## **Planning Conservation & Design Consultation**

**Consultation on Application Number:** 2018/92934 & 2018/92935

**Address:** Land adjacent, former Gees Garage, New Hey Road, Outlane, Huddersfield, HD3 3YJ

**Proposal:** Outline application for erection of residential development

Site Layout

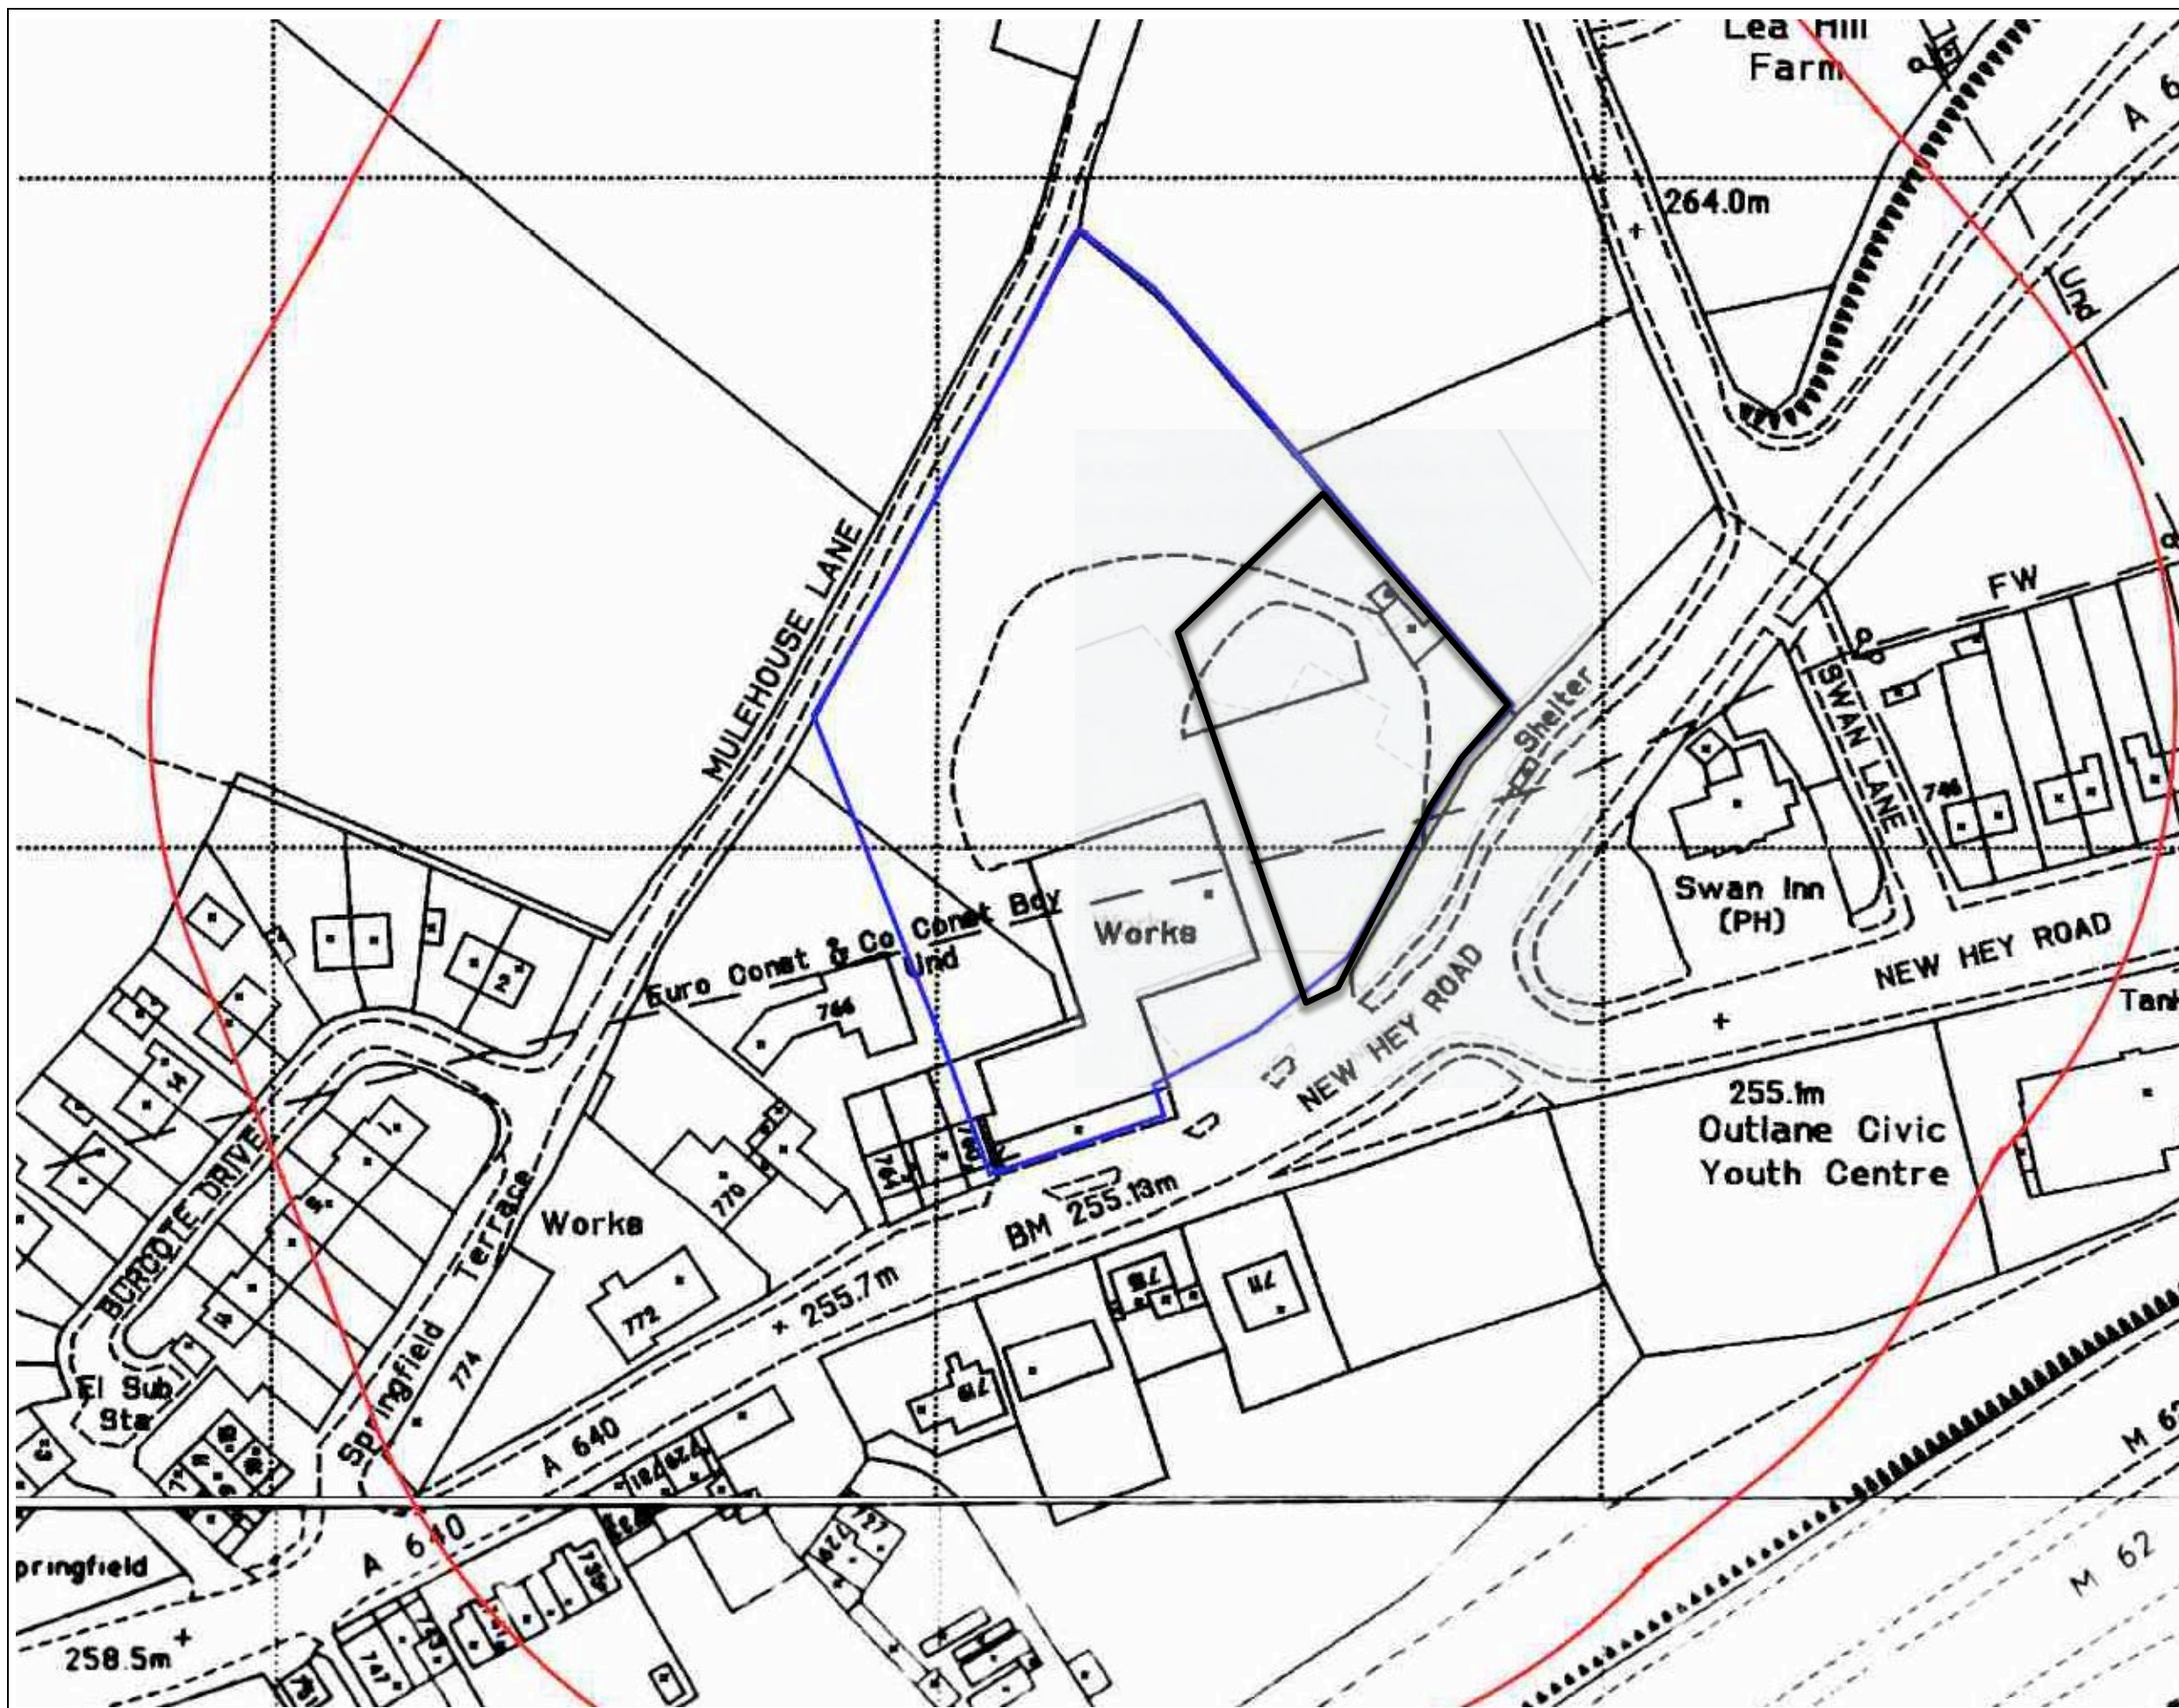
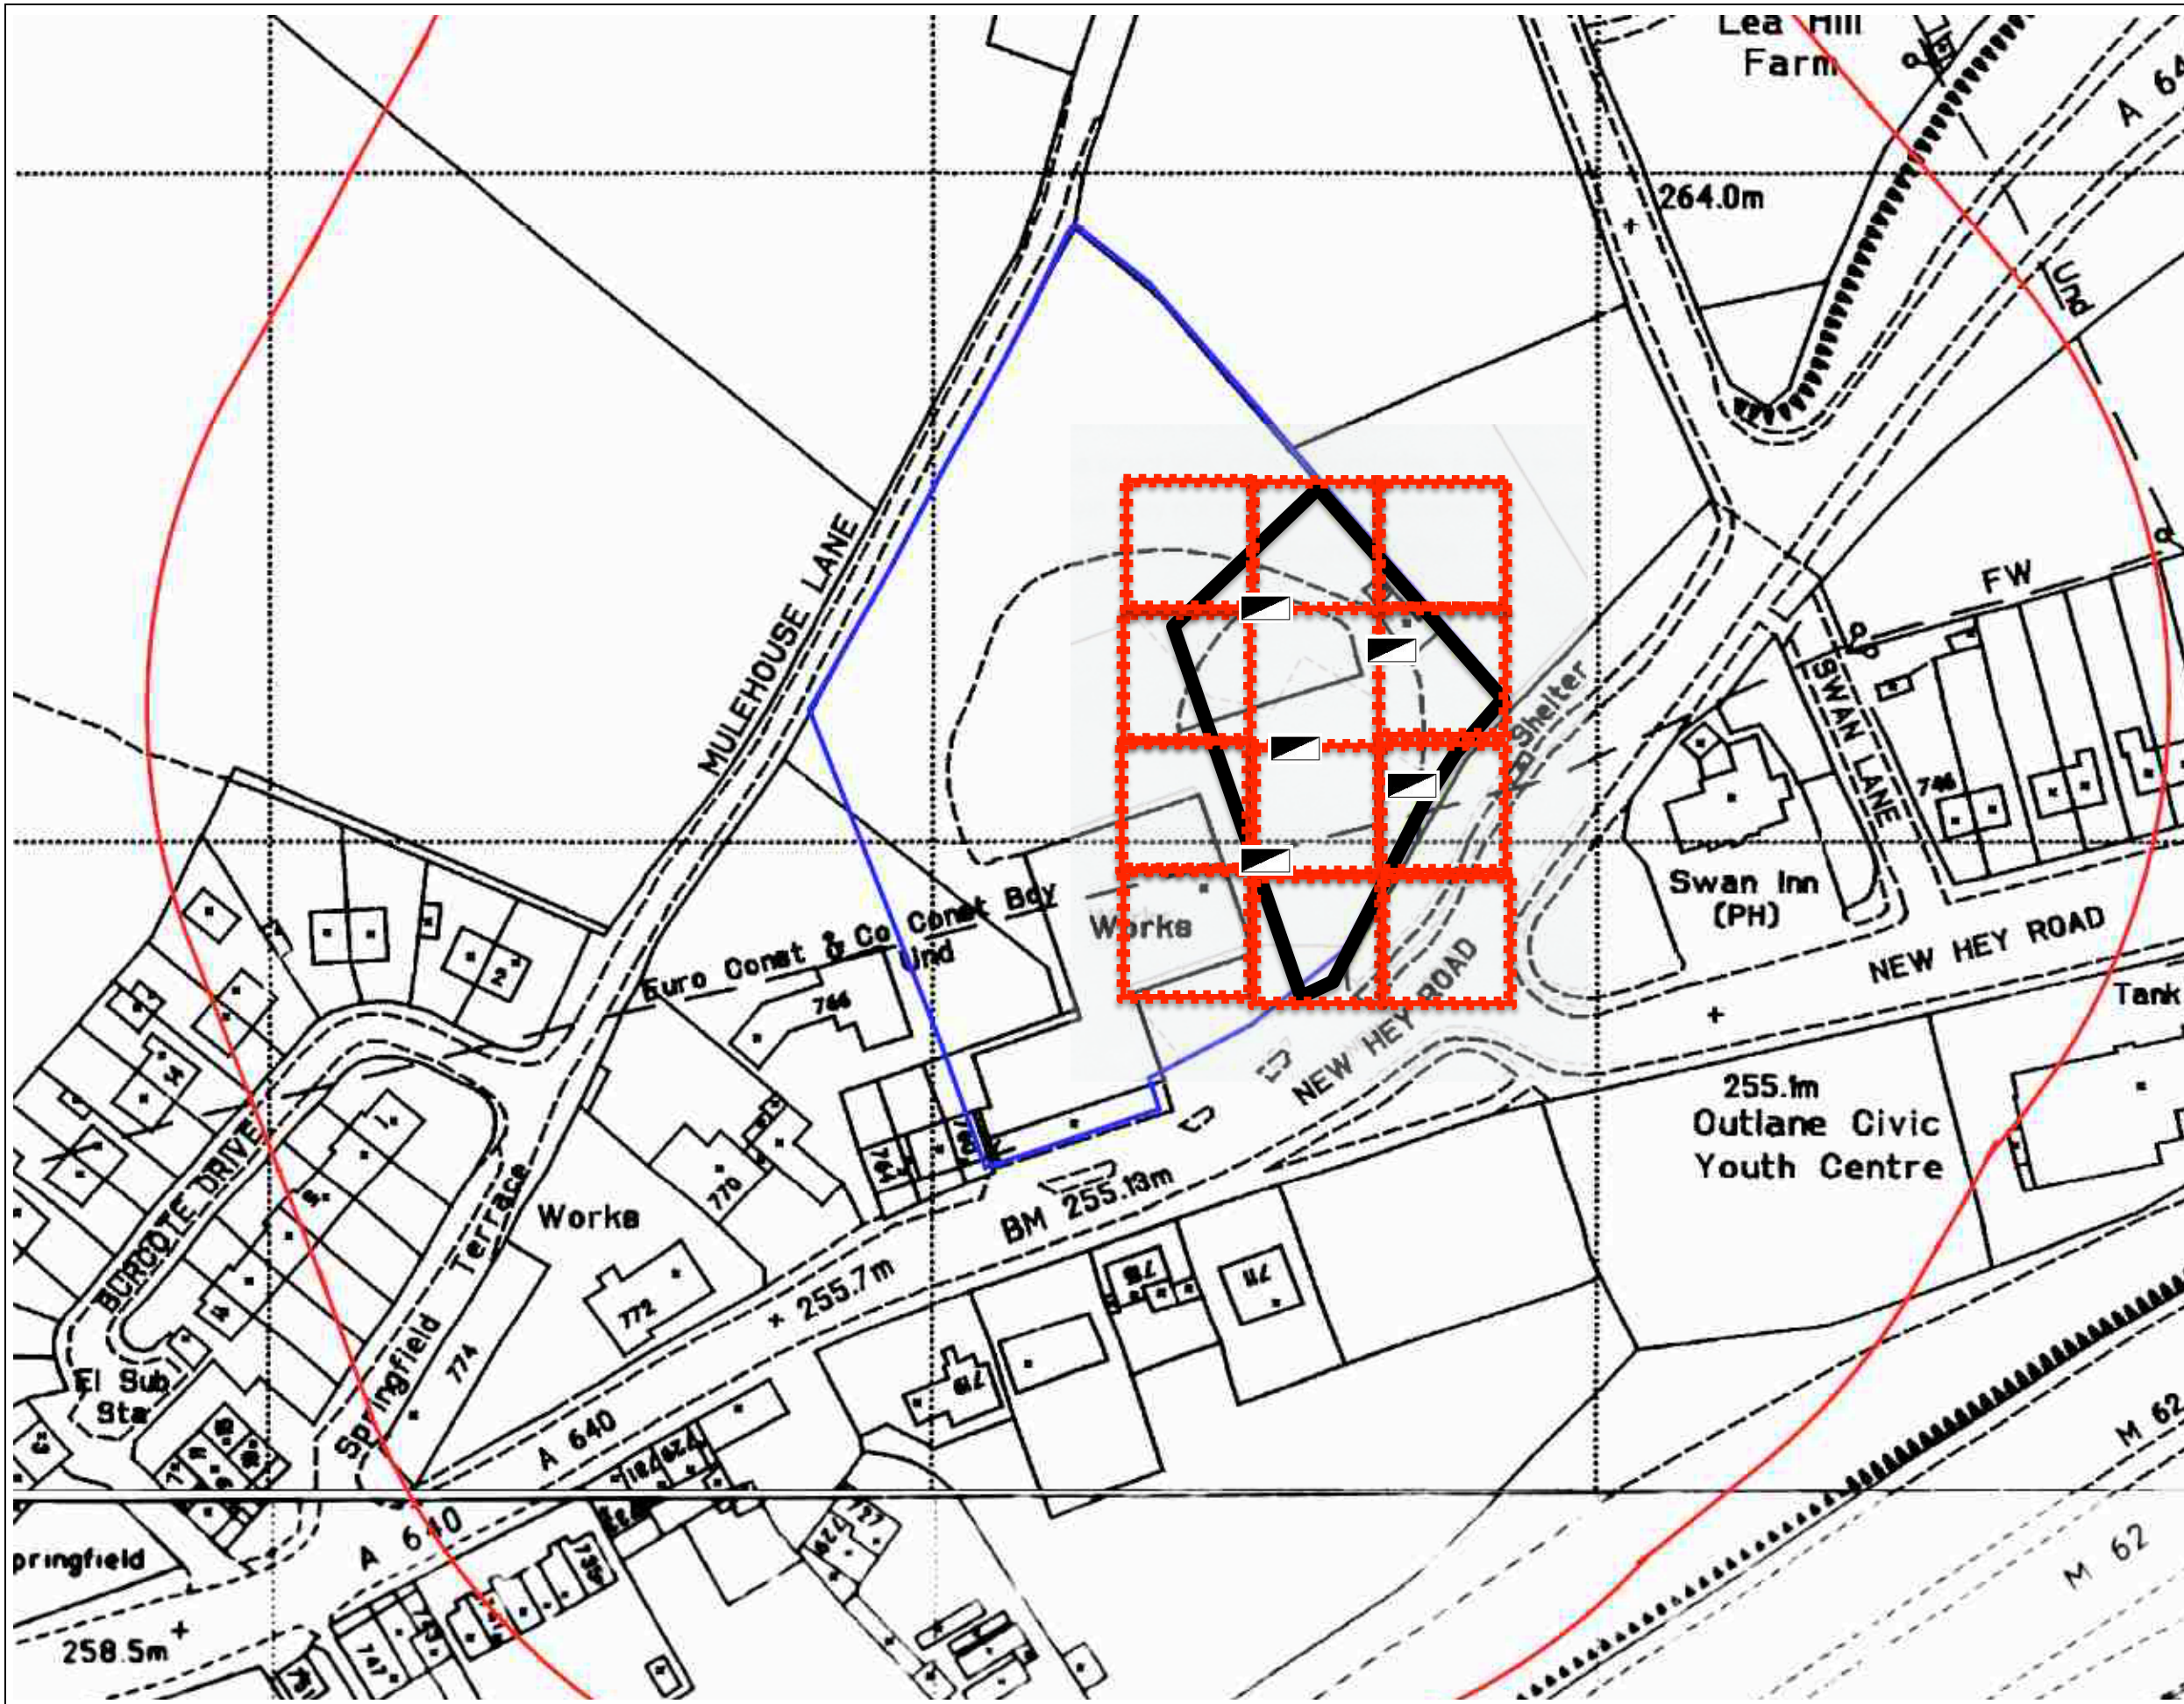
The proposed developments total 29 houses. Particular care should be given to the relationship between the new development and the main road. In application 2018/92935, consideration should be given to orientating plots 1-5 to front onto the main road to better respond to the character of the area in accordance with NPPF 2018 paragraph 130. There are not considered to be any impacts on any heritage assets arising from the proposal.
